## **HINCKLEY NATIONAL RAIL FREIGHT INTERCHANGE**

Project reference TR050007

### **Applicant's response to Deadline 5 Submissions [part 3 - LCC]**

Document reference: 18.19

Written Statement of Oral Case ISH6 [Appendix C – Plan for A47 link road footway/cycleway design]

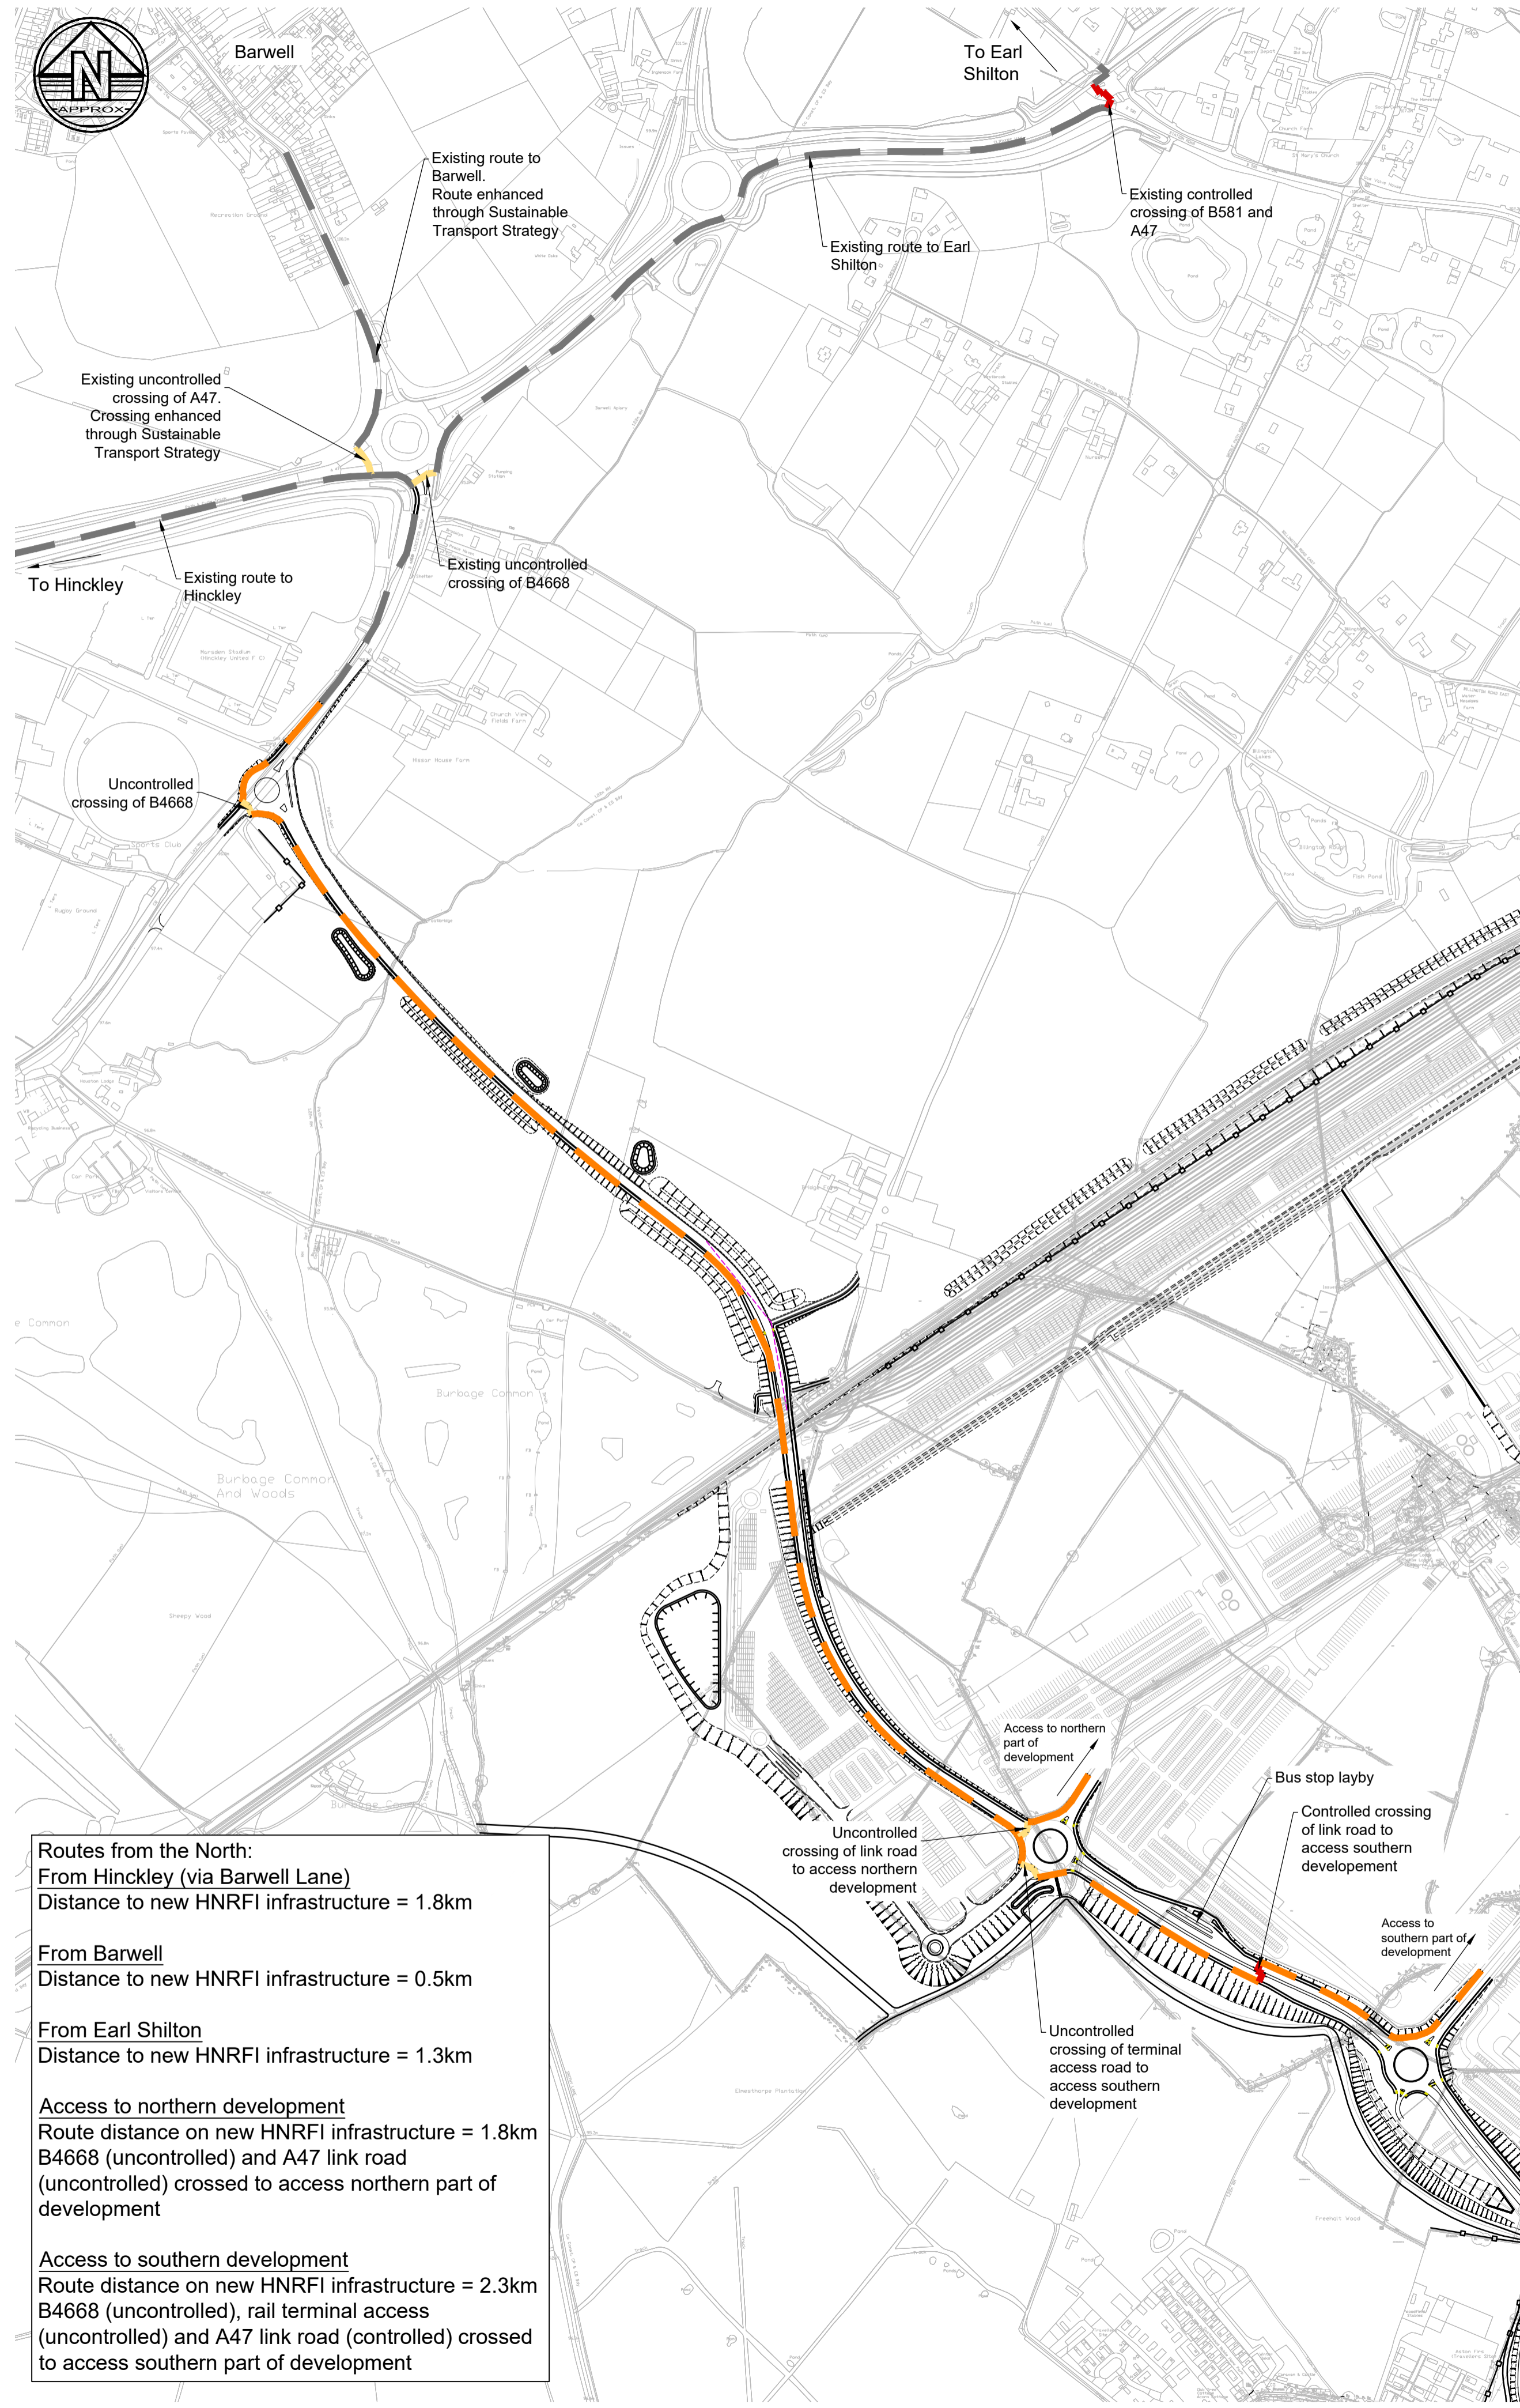
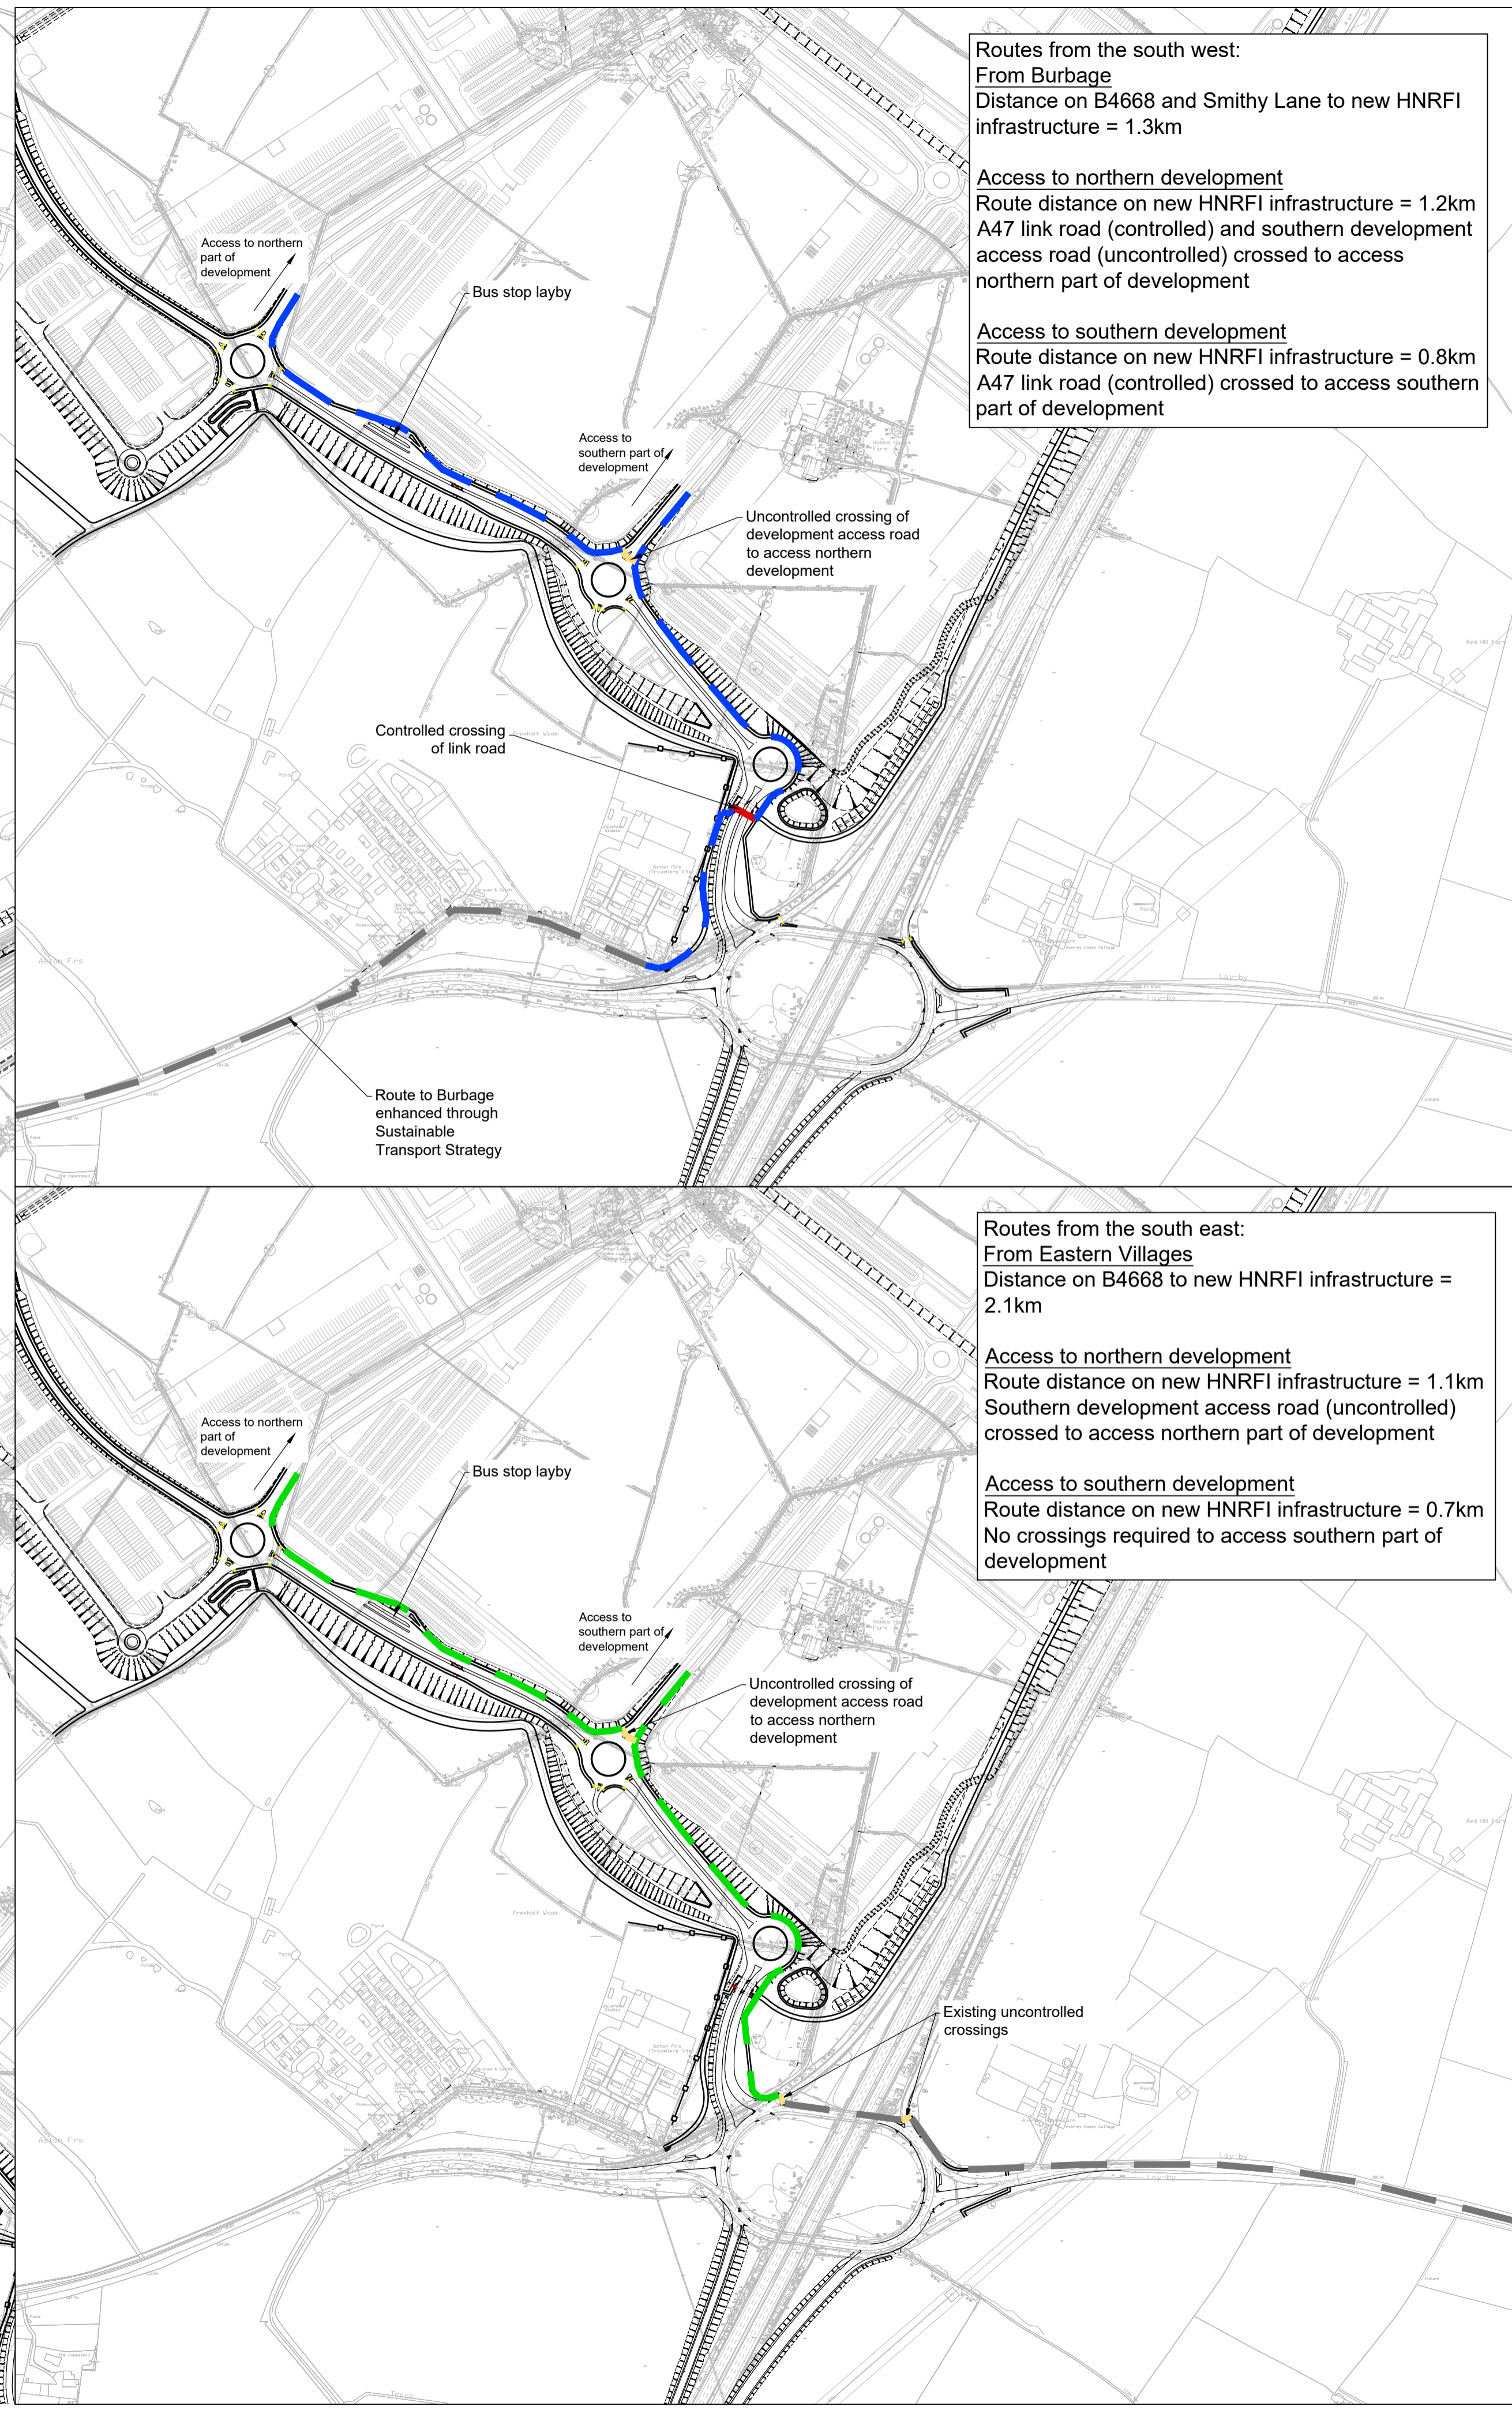
(i) At ISH2, the Applicant undertook to provide 1:500 drawings of the Link Road but said that there was continuous pedestrian and cycling facilities on each side of the Link Road. LCC has now been provided with the drawings and they do not show continuous pedestrian and cycling facilities on each side of the Link Road. As such, pedestrians and cyclists will have to cross the Link Road in order to navigate it.	A drawing illustrating footway/cycleway provision on the link road has been provided, along with narrative within the Applicant's Written Submission of Oral Case for ISH 6 at Deadline 5 (document reference: 18.5, REP5-025)
		(ii) At a meeting in November 2023 with the Applicant, LCC highlighted a number of walking and cycling proposals that LCC would expect a development at this scale and in this location would provide. The Applicant committed to review these proposals. However, at the next meeting in December 2023 the Applicant rowed back from them.	It should be noted that within the Sustainable Transport Strategy and Plan most recently updated at Deadline 6, (document reference: 6.2.8.1D) it is clear that a number of potential walking and cycling enhancements were reviewed in line with the commitment to do so made at the November meeting referred to. At the December meeting referred to, far from having 'rowed back' from these, the Applicant brought forward three of these enhancements to be committed to within the Sustainable Transport Strategy and Plan (document reference: 6.2.8.1D). Further to this meeting, additional lengths of footway/cycleway facilities were added between Smithy Lane and M69 J2 based on comments made by LCC.
